**RE: NOTICE OF EXHIBITION - SYDNEY METRO CITY AND SOUTHWEST (CHATSWOOD TO SYDENHAM) (SS1 7400 MOD 2)**

Thank you for inviting the Heritage Council of NSW (Heritage Council) to comment on and provide recommended conditions of approval for Modification 2 to the Sydney Metro City and Southwest (Chatswood to Sydenham) project (SSI 7400), to include Central Walk. I am responding as Delegate of the Heritage Council.

Figure 7-17 Central Station indicative combined services ring

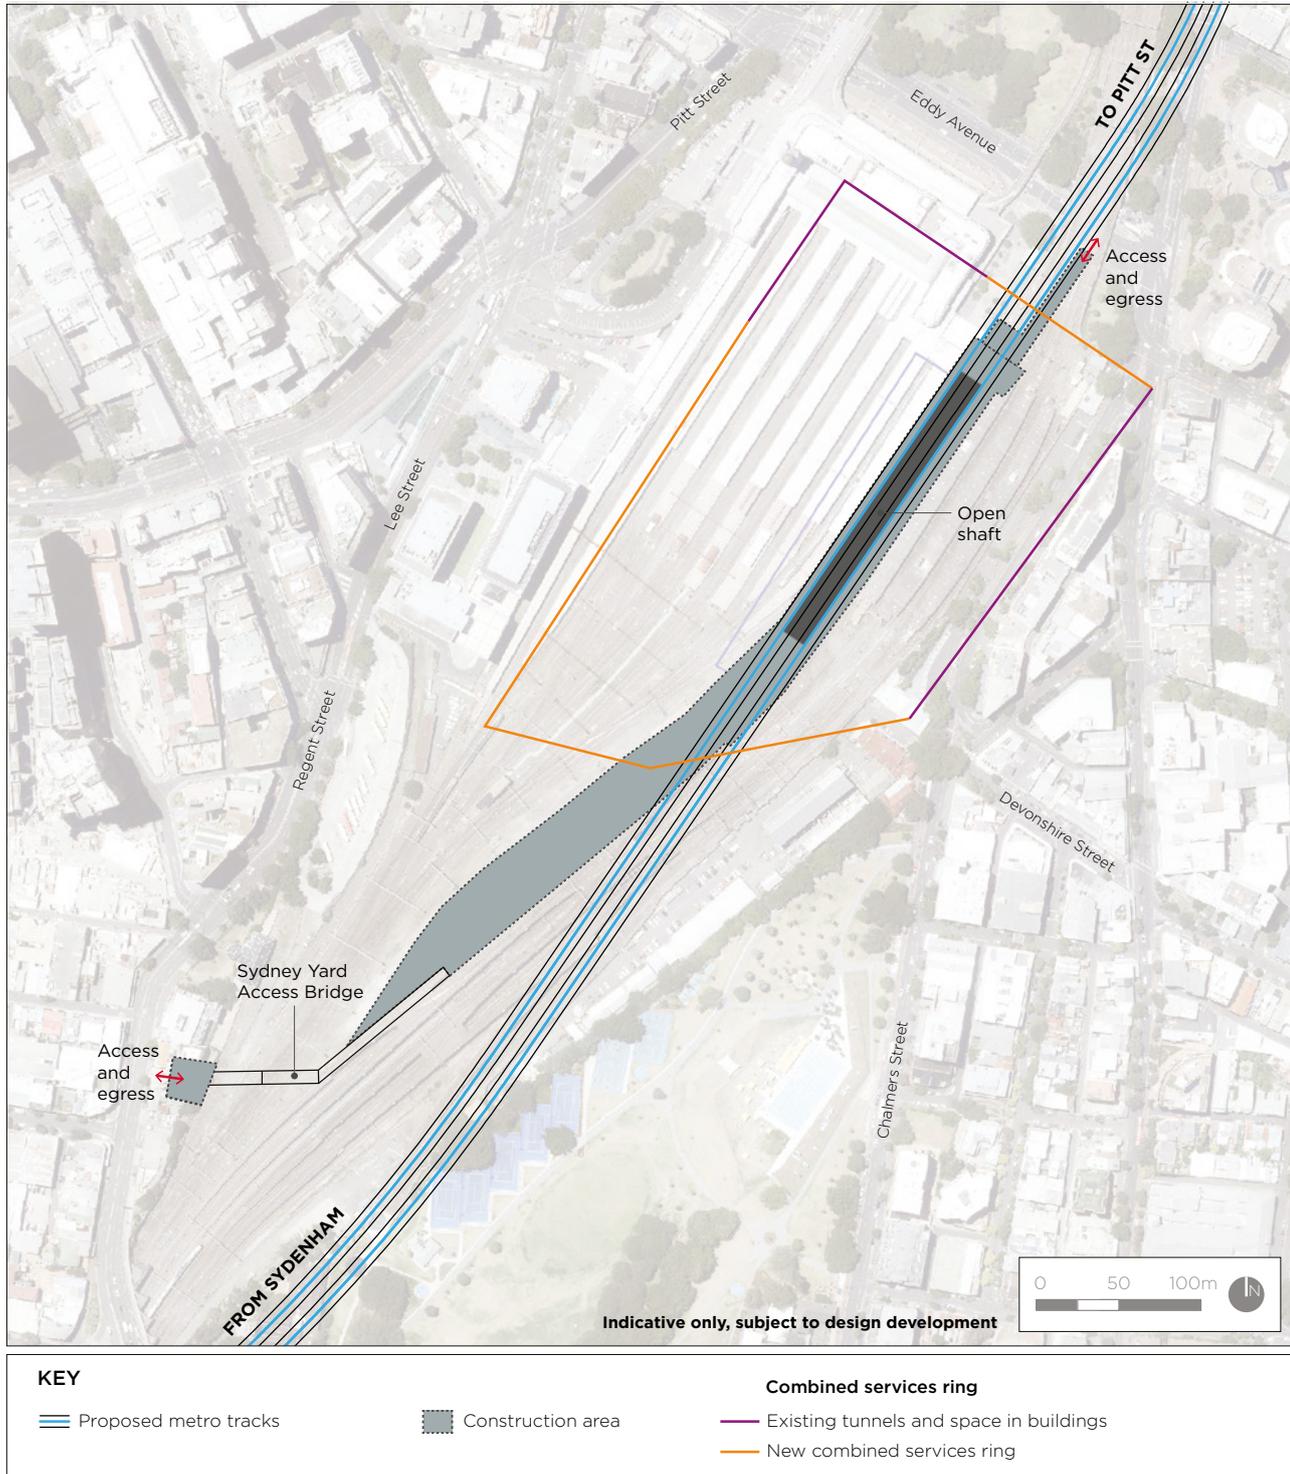
- A new combined services gantry is proposed south of Platforms 4/5. The project description notes that the design of the gantry would follow the Metro Design Guidelines, and services would be encased to minimise visual impacts. In addition, the gantry should be sized, sited and painted to reduce visual impacts as much as possible.

- the gantry to carry the modified combined services route to the south of the intercity platforms should be avoided or designed to minimise visual impacts as much as possible.
- City of Sydney Council should be consulted during detailed design stage and invited to comment where urban character and local heritage items would be affected by the modified project and the demolition of the *Former MGM Building* ('Bounce Hostel').
